SUNSET VILLAGE FILING NO. 4

CONSTRUCTION PLANS

EPC STORMWATER REVIEW COMMENTS
IN ORANGE BOXES WITH BLACK TEXT

MODIFIED FOR S.I.A. CD SET
RICHARD D. LYON, PE
ATWELL, LLC
DECEMBER, 2021
EPC PROJ.: CDR-21-008

PHASE 1 (JAYHAWK AVENUE)

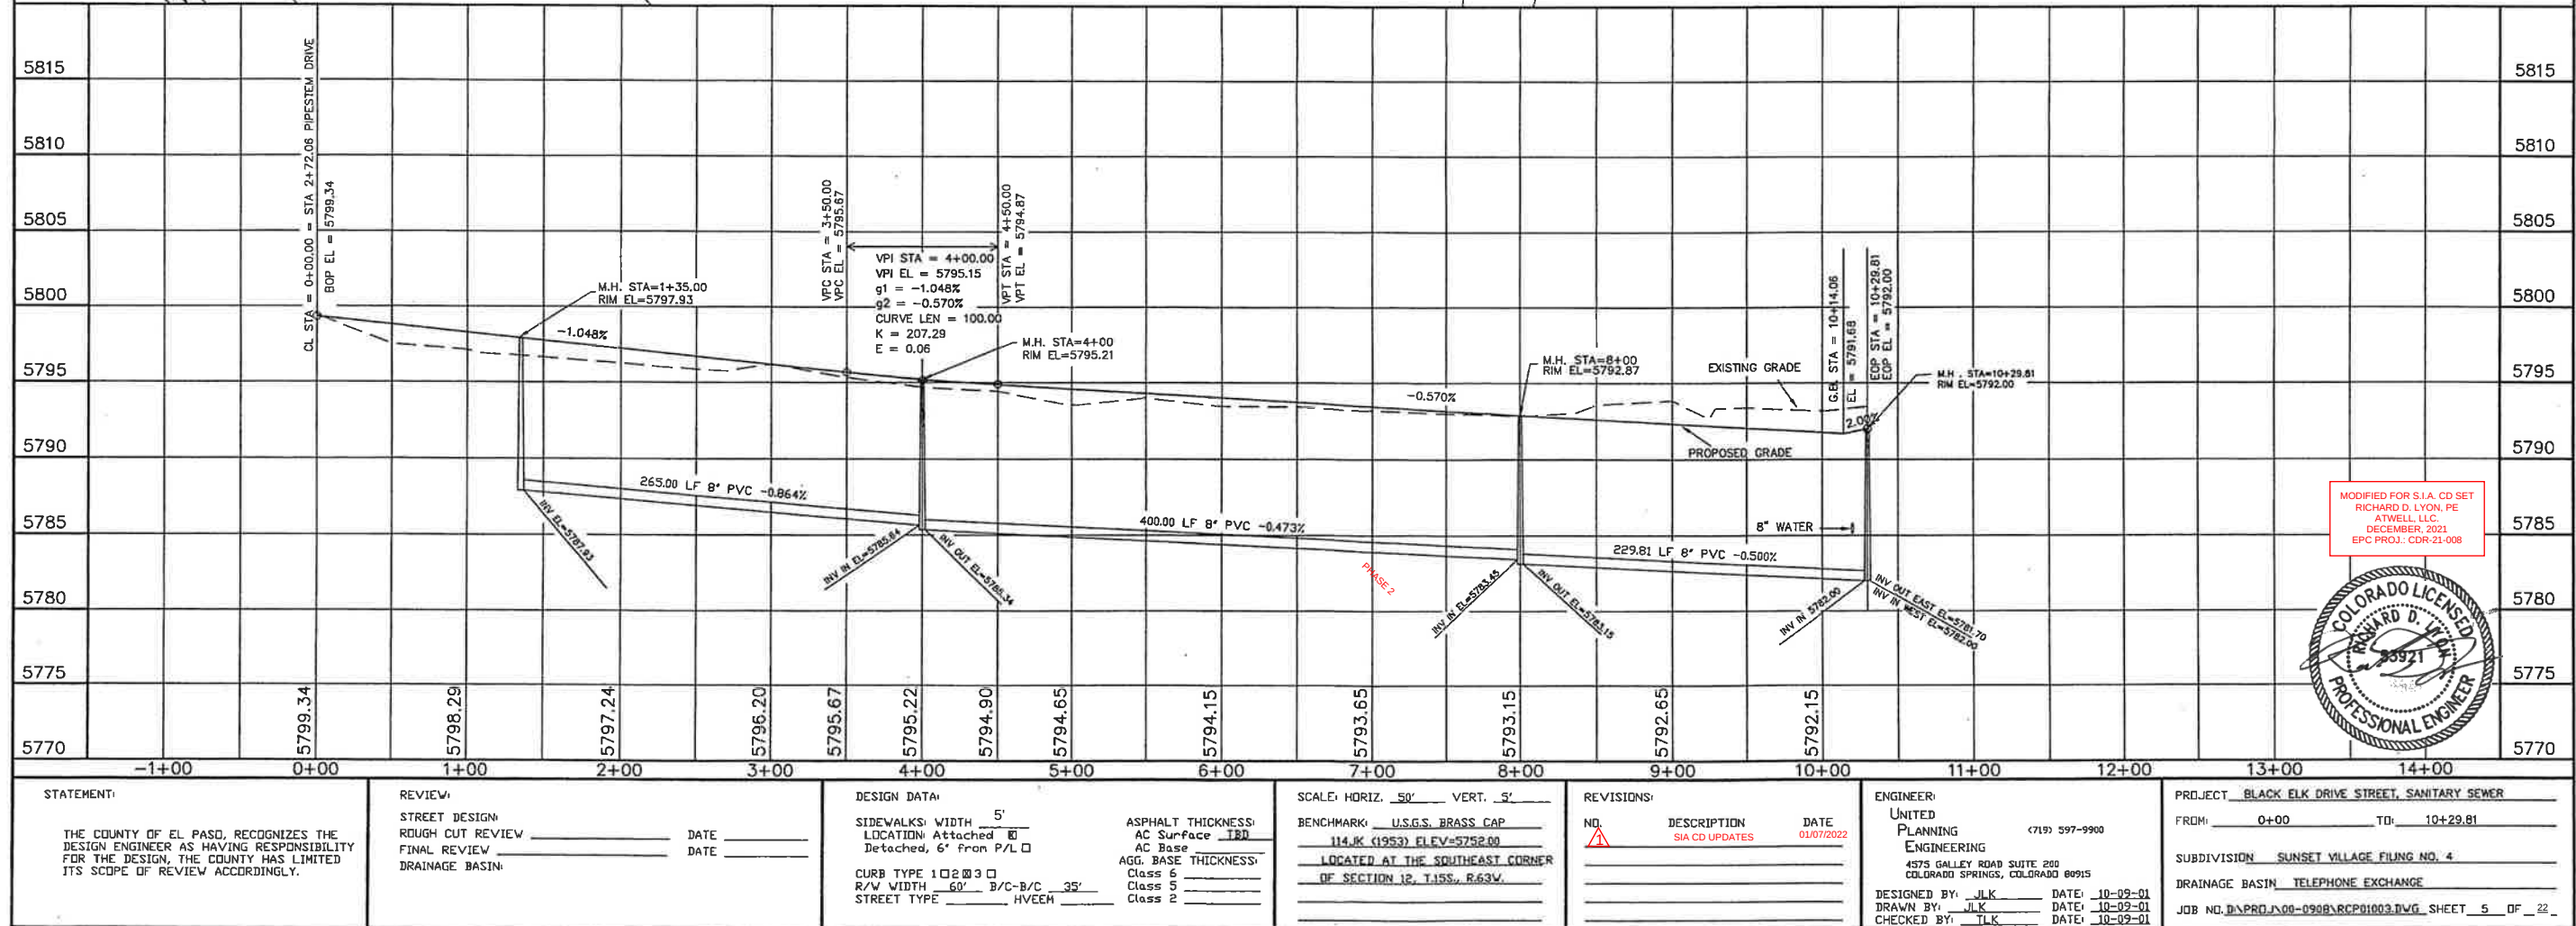
Relocate ramp to the other side. The current design bisects Lot 19 and has a high likelihood of conflicting with the future driveway location for lot 19. On Lot 20 the parallel ramp is closer to the lot line, leaving a wider frontage for future driveway.
Check the other ramp locations.
